Project Title: Hotel Chaco Building Permit # _____ City Drainage #: J13/D066

To: gmeans@highmesacg.com
Subject: J13D066 - Hotel Chacao

Given the sad news, it makes sense as to why you are taking over this project – Hotel Chaco. When I first reviewed it, Jeff had walked me through all the calculations and drawings. I am reviewing the revised plans, and understand that some of the proposed changes are to use water quality manholes in lieu of the cisterns. Given the circumstances, this email is being sent in lieu of an attached comment letter in order to expedite the review. Here are some questions regarding the changes:

©2014 Gensler

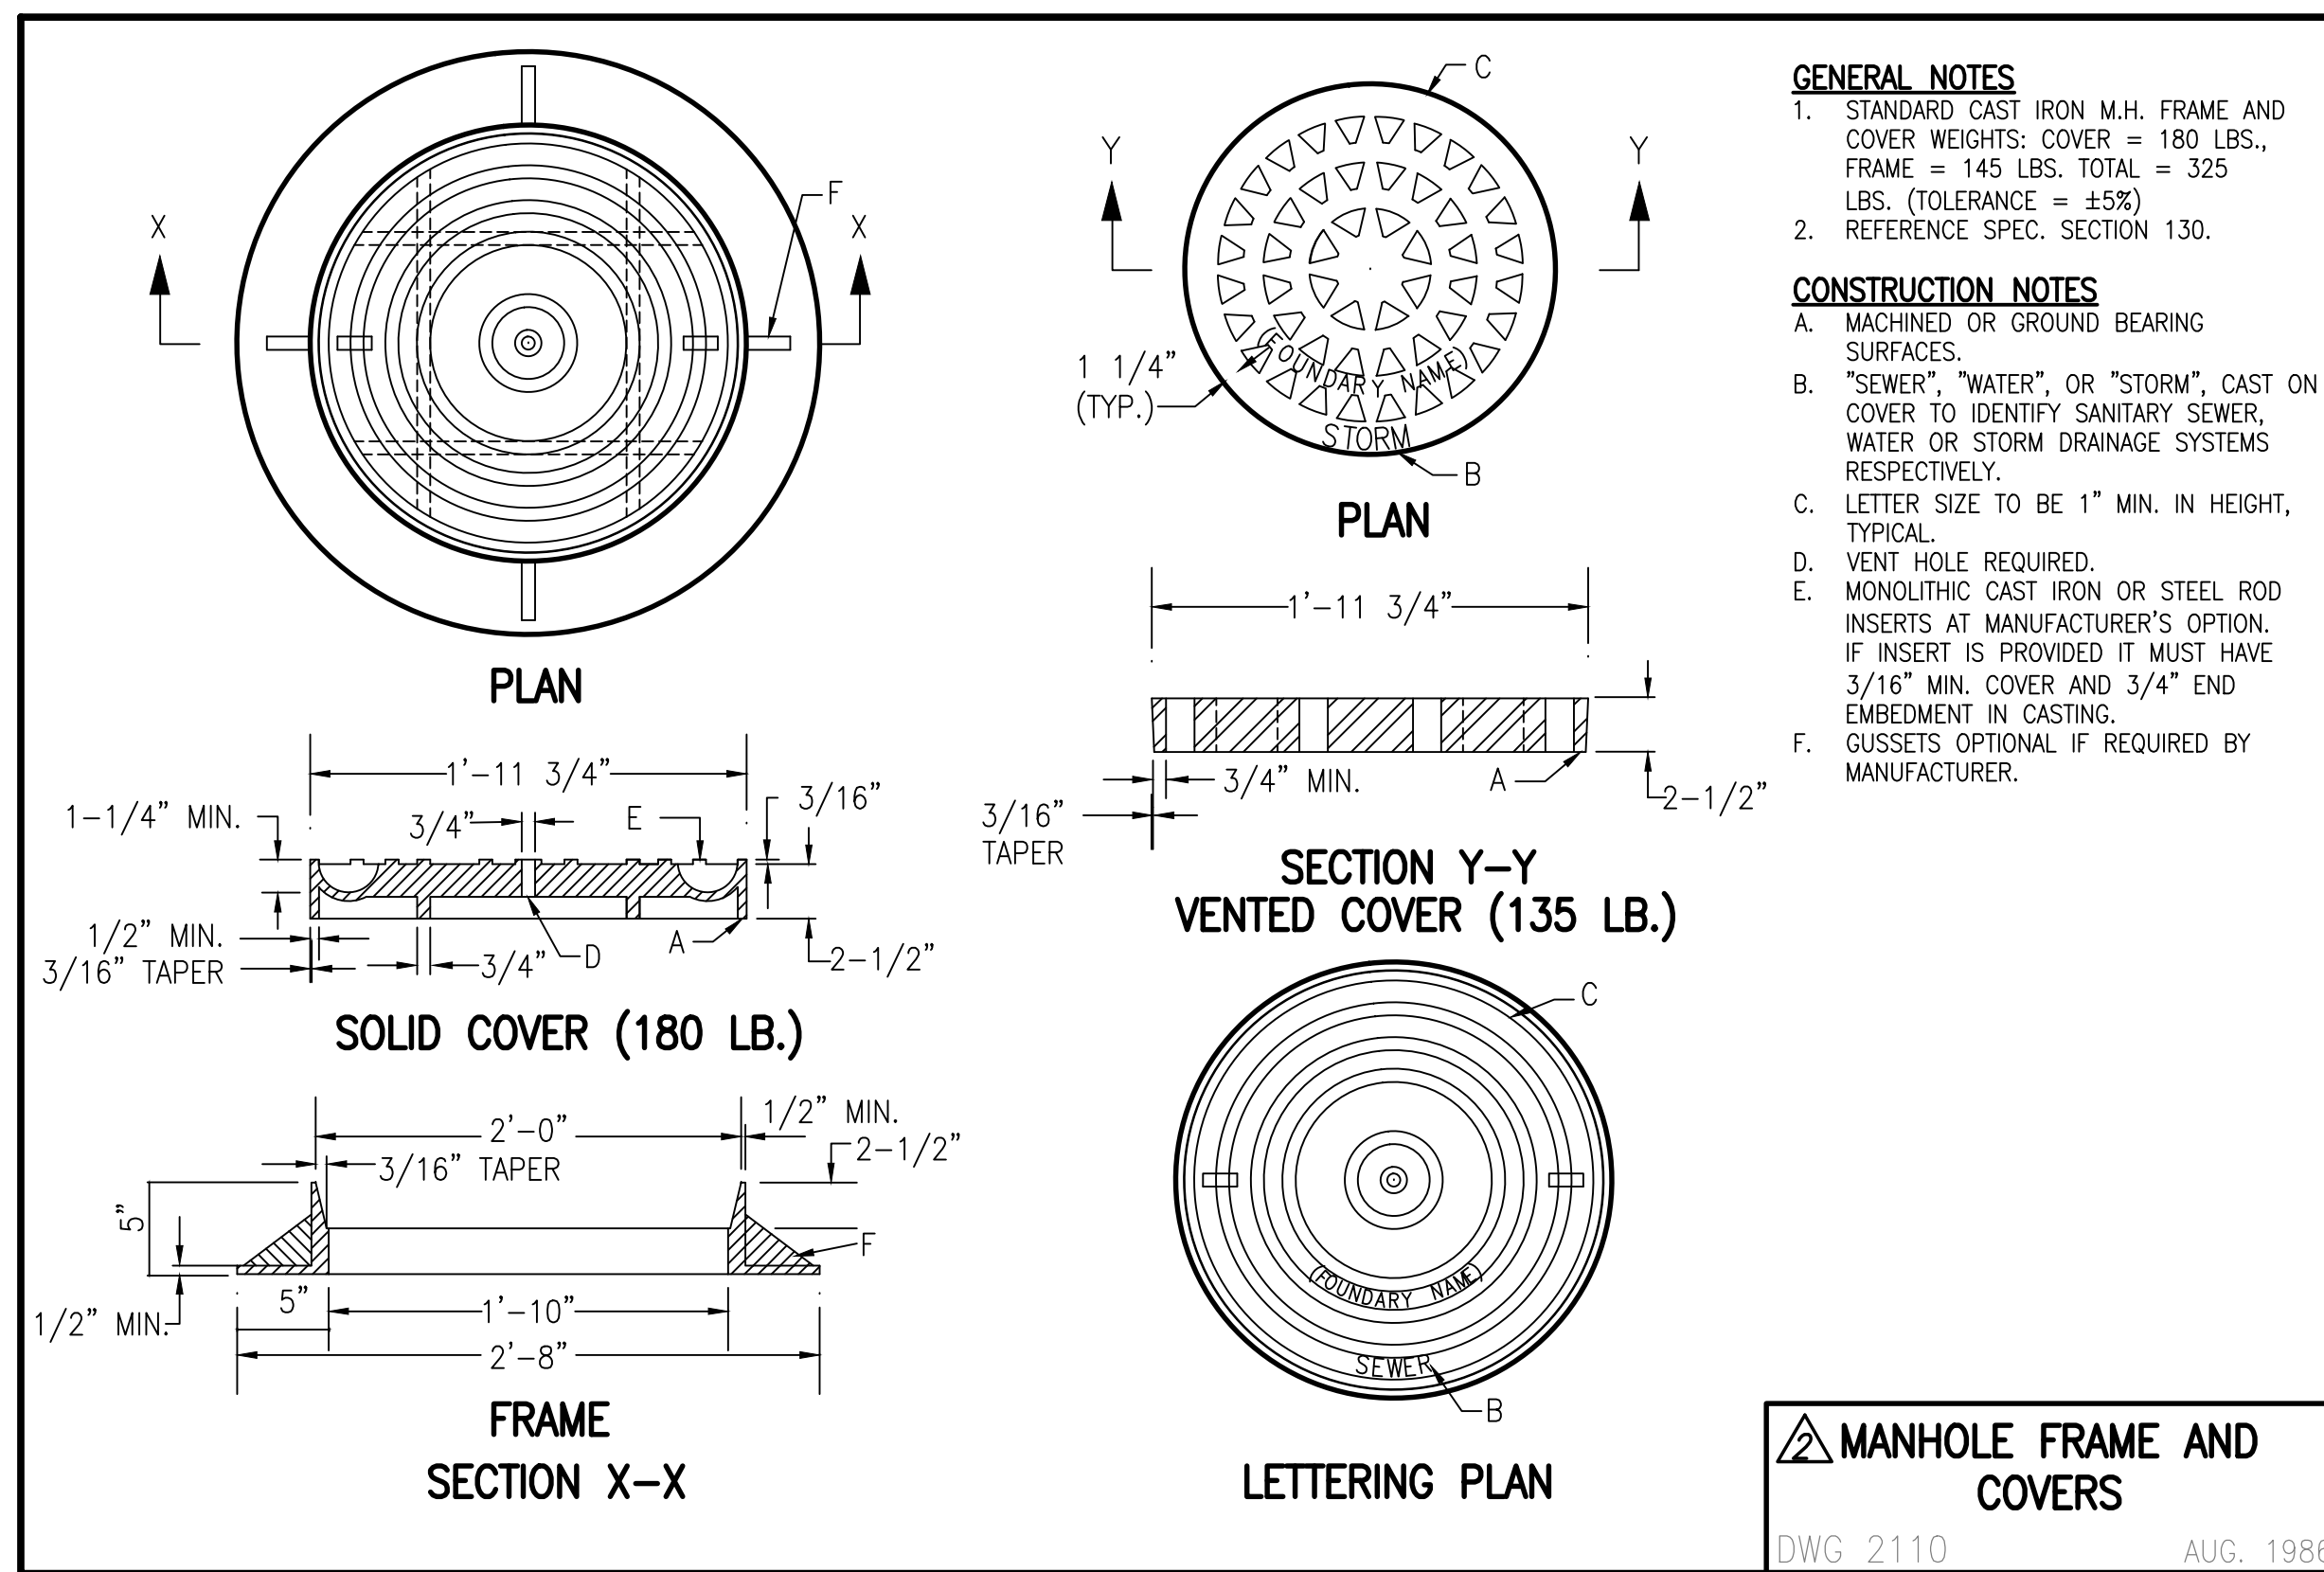
- 1) Original calculation sheet show that the cisterns were used to catch the first ½" of runoff, (In the Valley, discharge is limited to either 2.75cfs/acre, or detain the first ½" of runoff.) Do the proposed Water Quality Manholes capture the same volume of runoff? If the new Manholes are not holding the same volume, then are you going to limit the discharge rate?

- 2) The Manhole details show pea gravel at the bottom. Is the intention to allow runoff to percolate into the soil? If so, we need a letter/email from the Geotech stating that such seepage into the soil will not undermine the structural foundations.

- 3) The site is adjacent to a flood zone, and this has caused some concerns. If flooding occurs in 20th street, then discharging into 20th street will worsen the flooding depth and limits. The cisterns were allowed because water could be pumped out of them when any flooding in 20th street had subsided.

- 4) If 20th Street floods (and it often does with lesser than 100-yr. storms), the proposed sidewalk culvert could be allowing street flows into the manhole and filling the manhole faster than flows from the site itself.

Look forward to any additional volume you are able to find on the site to offset the cisterns. When we spoke about them last time i did not know that the site is within, and feeds, directly into an AH Zone.. I thought the cisterns were to offset first flush volume, which is why I suggested the WQ manholes to enhance the treatment effort like on your BMW site and a couple of other APS projects.

With the AH Zone impact, you will in fact need to provide the volume that was in Jeff's original plan. This site is a big contributor to the basin, and several buildings are already clipped by the Zone; there is also a building with a recently approved LOMA that could be impacted.

Alternatively, you could also consider maximizing the volume of your site as much as possible, and then present an analysis of the basin to show that the impact to the elevation of the BFE is negligible. For example (and using very rough approximations), the surface area of the floodzone is about 370,000 SF. A negligible rise of 0.05 inches gives an allowable volume of about 1500 CF.

How much water would have been captured by the cisterns? (i.e. how much more water are you now proposing to feed into the floodzone?)

Keep in mind that even if the amount is small, we will still need you to maximize the retainage for first flush to the extent practicable, and then we can consider the wq manholes..

As for the Hotel Chaco resubmittal, I came in an met with Abiel several weeks ago regarding the proposed deletion of the cistern. The reality of cisterns is that during the rainy season they are usually full, so the associated volume may not be there for any retention. For this site, most of the landscaped areas will be depressed with an unquantified volume of storage. We propose that this meets the intent of the ordinance. Abiel requested we provide the water quality manhole to provide pollutant control for the roofwater (bird poop) which is what we did. If you need buy-in from the Geotechnical engineer, we can pursue that.

As for the sidewalk culverts, Abiel suggested them in lieu of the curb penetrations previously proposed because we understand that they are discouraged and problematic. Yes, they can run backwards if the street is full, but that is no different than the curb penetration scenario in the previous submittal. We will see if there's a way to reduce or limit the potential.

As for limiting discharge, the plan does have several landscaped areas that are depressed, and we understand that the landscape architect intends to make the depressions a bit deeper than designed.
